**ADC Planning Consultation
Response from the Conservation Officer**

Application Number	LU/194/15/L
Address	7 River Road Littlehampton BN17 5BN
Description	Application for Listed Building Consent for the restoration of front garden wall. Construction of two pillars to accept iron gate and refix iron railings atop stone coping.
Case Officer	Mr. D Easton

7 River Road
Plan View
Scale 1:50

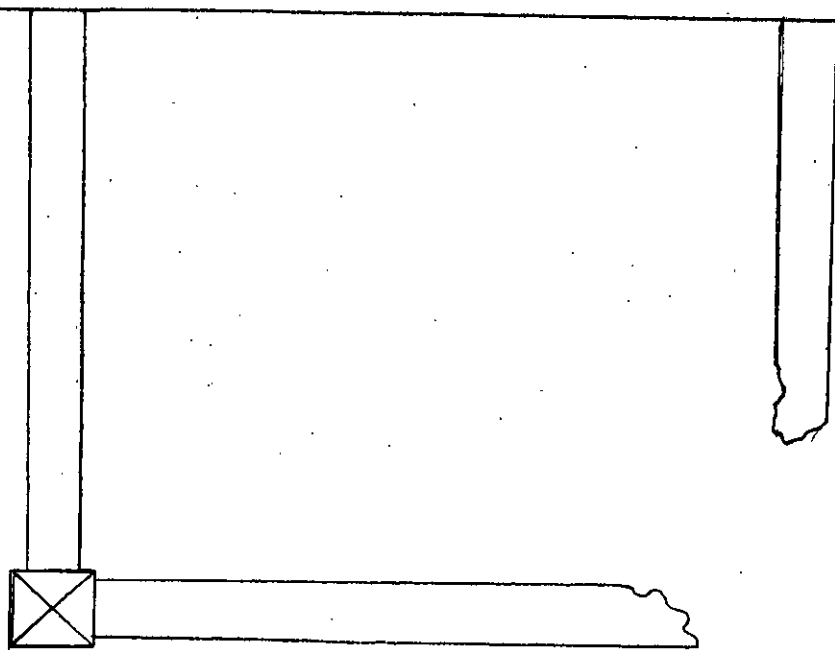
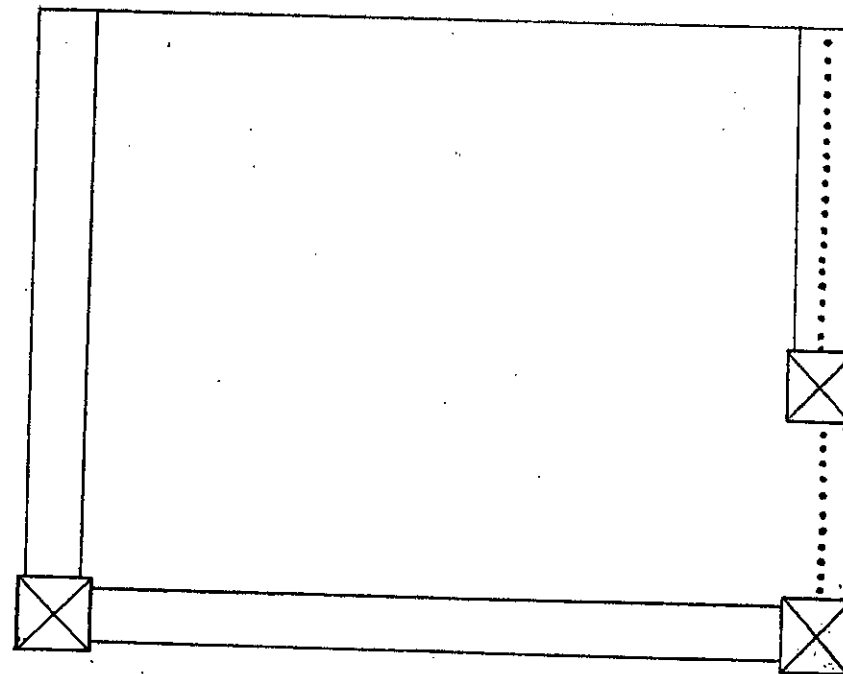
The proposal to reinstate the wall to its previous appearance is supported.

The use of railings is supported as it will enhance both the property and the local area.

Please condition details/sample of railing as well as the colour of the railings and the wall.
